Demolition of existing building & construction of 1 No retail unit & 3 No. flats with associated external works & access. This application affects the setting of listed buildings & may affect the character & appearance of the River Road, Littlehampton Conservation Area.

Littlehampton Covered Market 26-28 Surrey Street Littlehampton

Thank you for your internet representation made on 14th April 2020 which has been recorded as '**an objection**' with the comments as follows:

Proposed Plans And Elevations

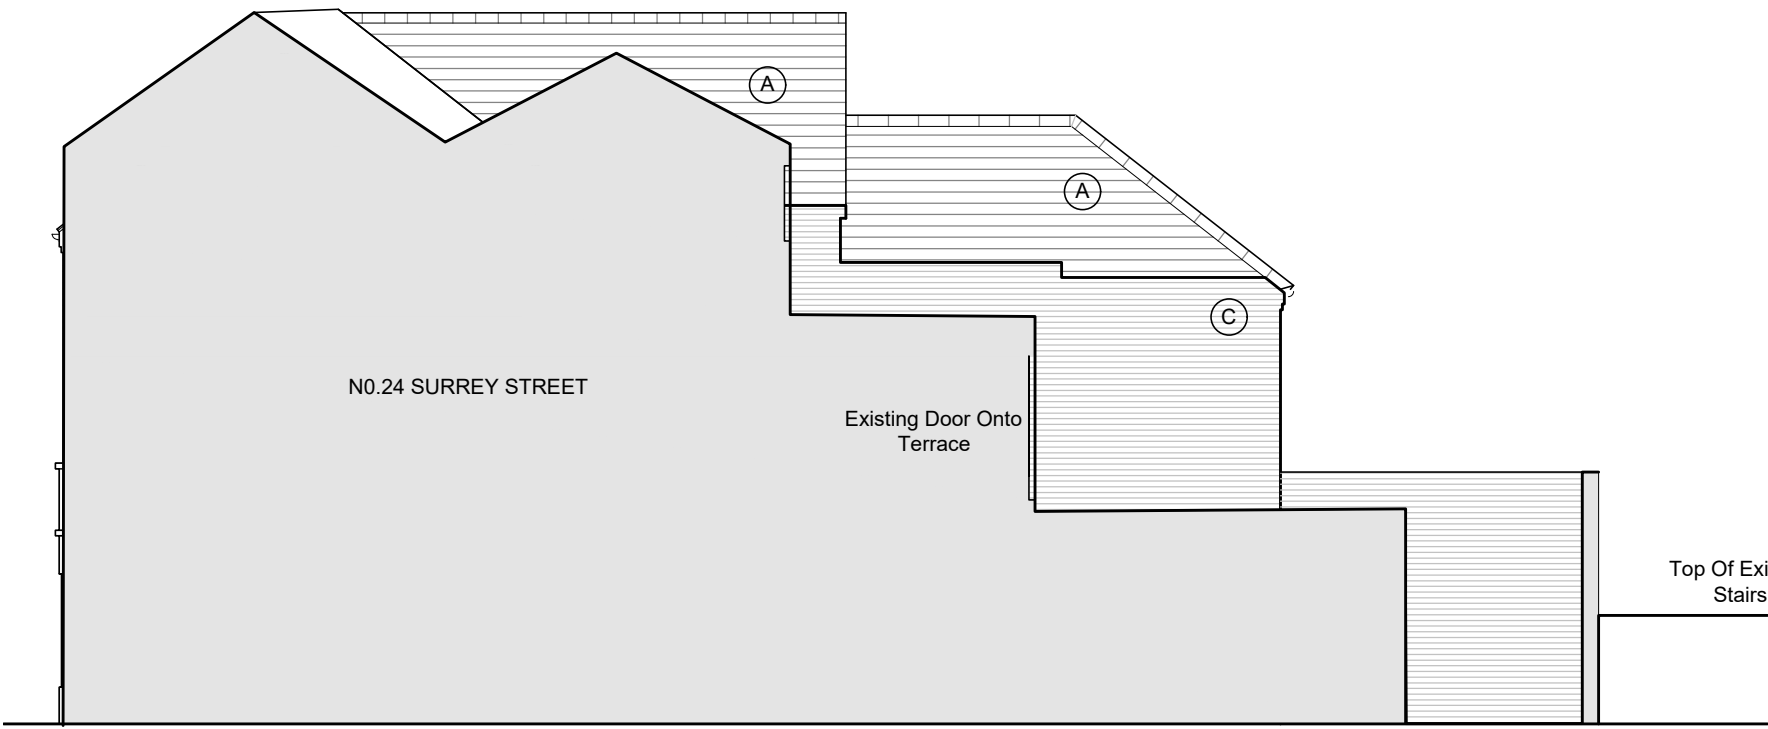
*I object to the loss of an original flint walled C19 building. The proposed design of the replacement appears alien to its neighbours, listed buildings at 20, 22 and 24 and 32 looking at the elevations. In terms of design, layout and scale. ..
It seems to me conversion of the original, or a replica, would be more in keeping and looking at the street scene a couple of dormers would probably appear acceptable. Vital to get the opinion of the heritage officer. I note LU/390/17/PL was refused on heritage grounds.*
